Our ref: WA/2021/129266/01-L01
Your ref: 21/02286/F
Date: 13 September 2021

Construction of a coffee unit with drive-thru facility and indoor seating with associated access, car parking, landscaping and servicing parking

Land North West of Launton Road roundabout adjoining Skimmingdish Lane, Caversfield

Environment Agency position

DRAINAGE LAYOUT

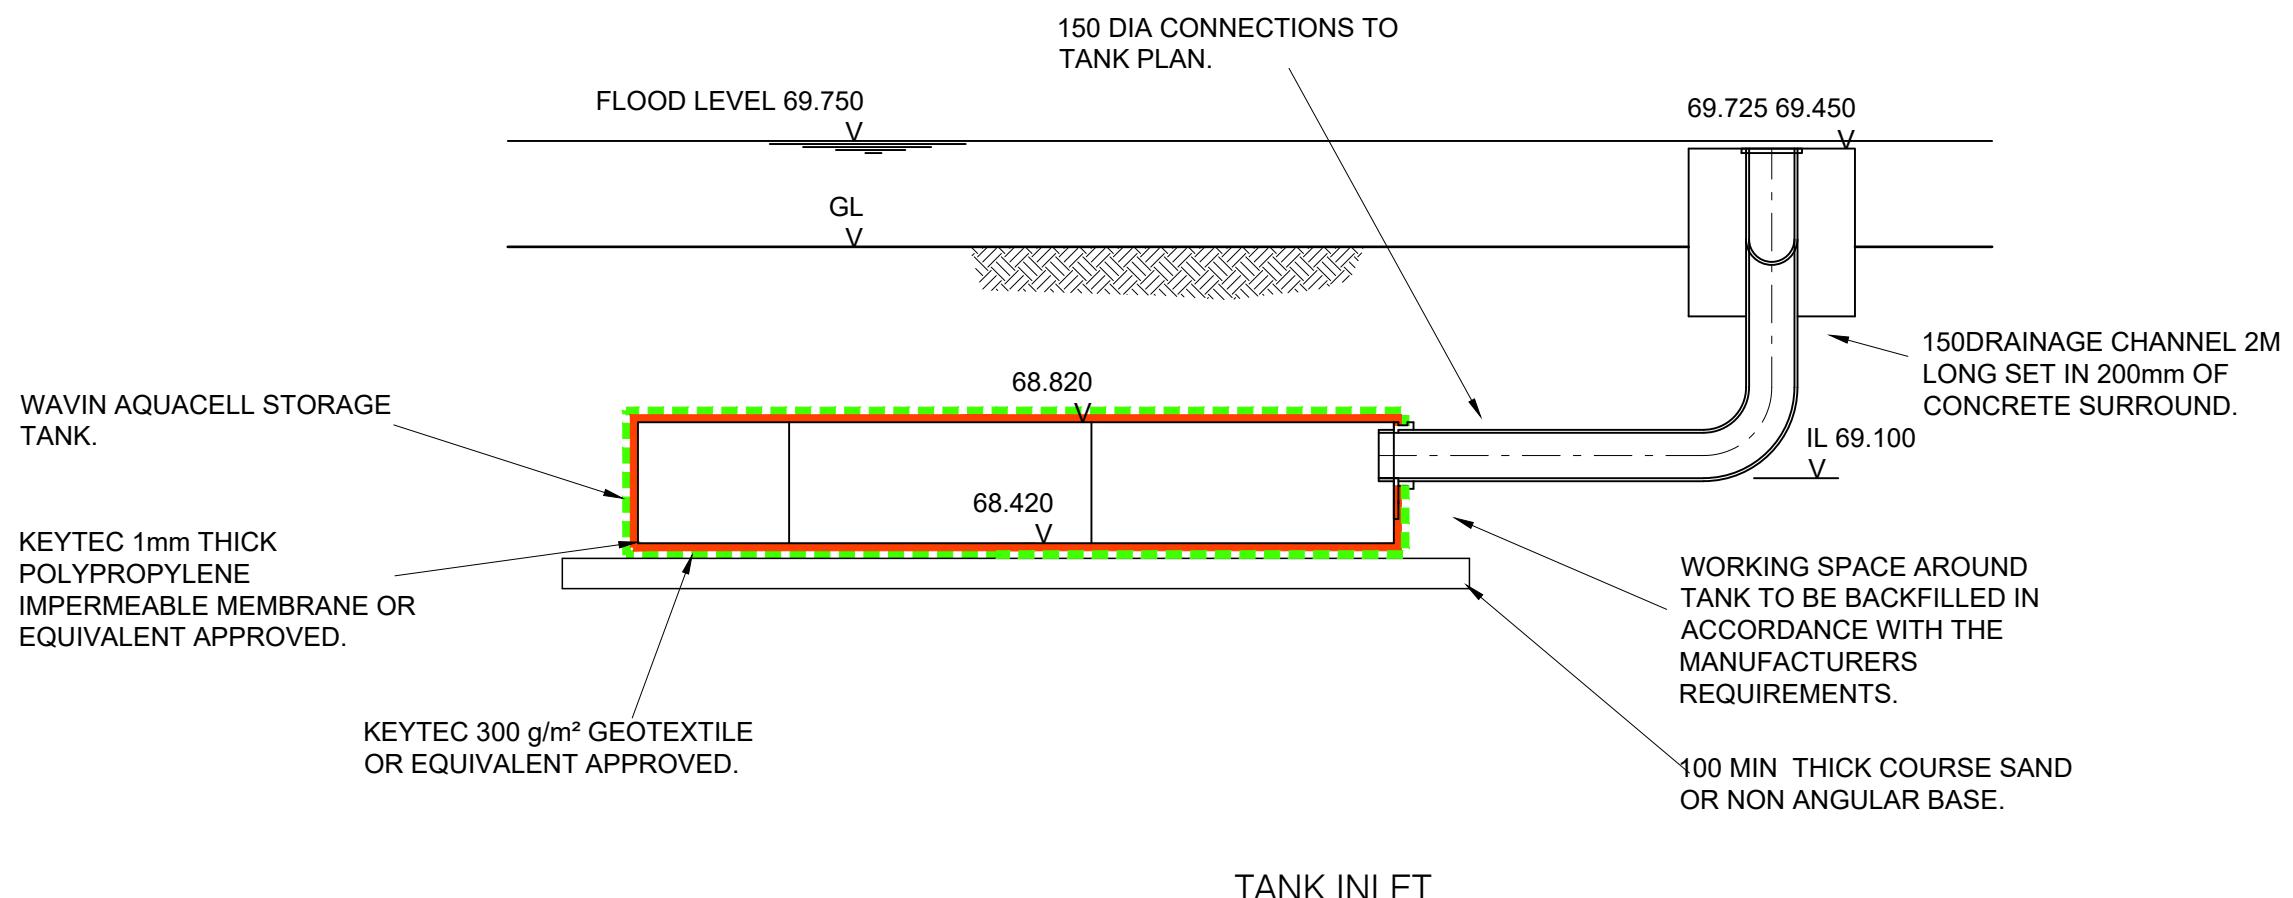
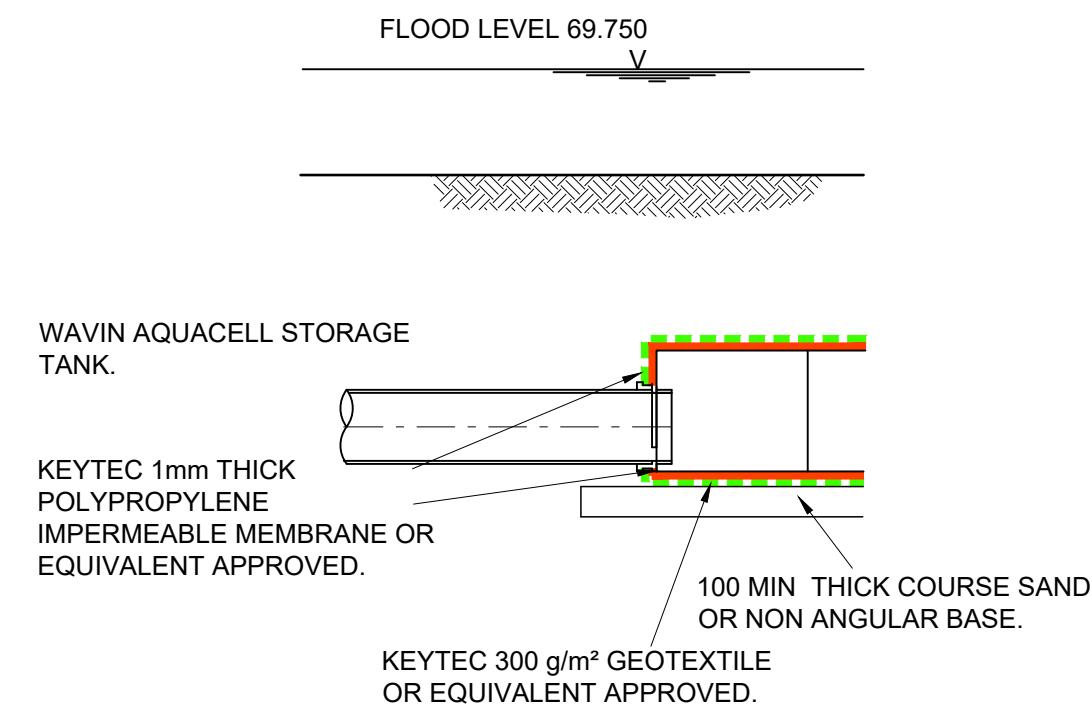
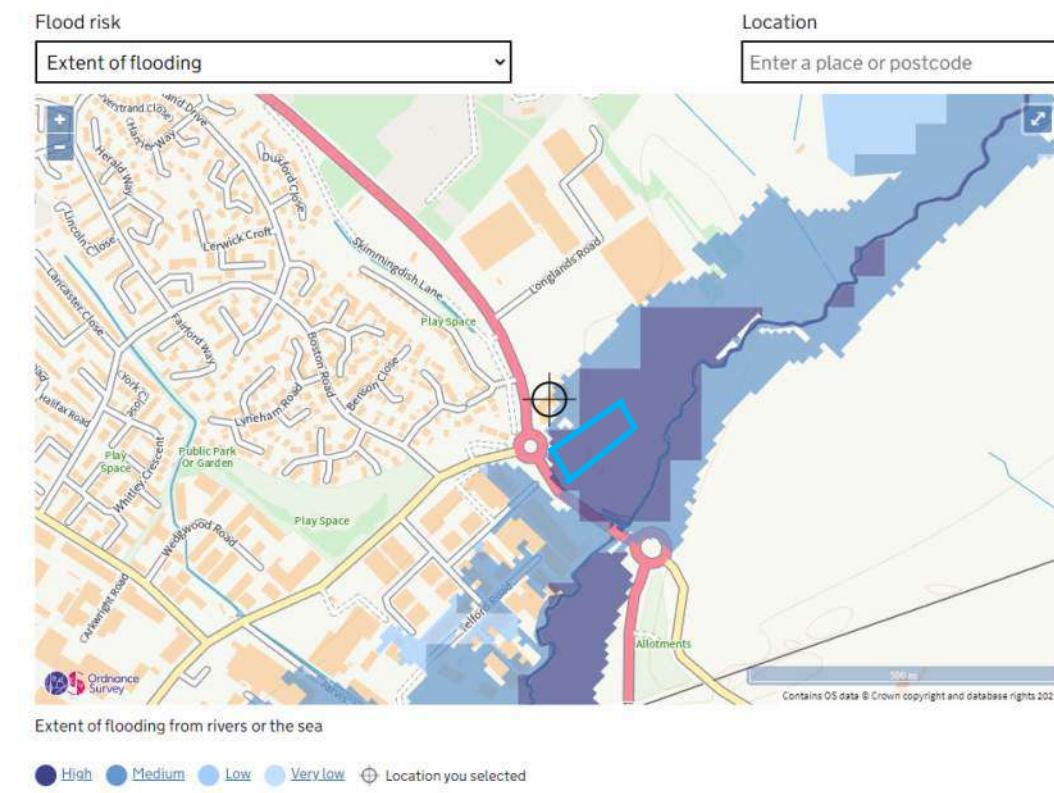
At that time the assessment of the compensation storage required for the tank system was 30m³. We note that that requirement has now more than doubled to 66m³. We consider tanks to be inappropriate for this size of compensation storage. We would prefer a void undercroft to the proposed building/development and we urge the applicant to re-consider the proposed design.

The underground tank approach is not something we would normally accept. In cases such as this, where there is limited space to provide land level adjustment to provide the necessary level for level flood storage compensation volumes, we would normally only considered an open void beneath the building appropriate so long as it met our criteria and was acceptable to the local planning authority.

If the development can be arranged such that the tanked storage required is much smaller, more akin to what was previously proposed, then we could consider it further. However, the applicant needs to demonstrate that it can be easily inspected to determine if silt is present in the tanks and accessed to allow any silt accumulation to be removed such that the tanks can be adequately maintained to provide effective flood

storage over the lifetime of the development. The present details within the FRA are insufficient, they do not show any access for maintenance/inspection to the tanks or any method of removing silt accumulation from the tanks.
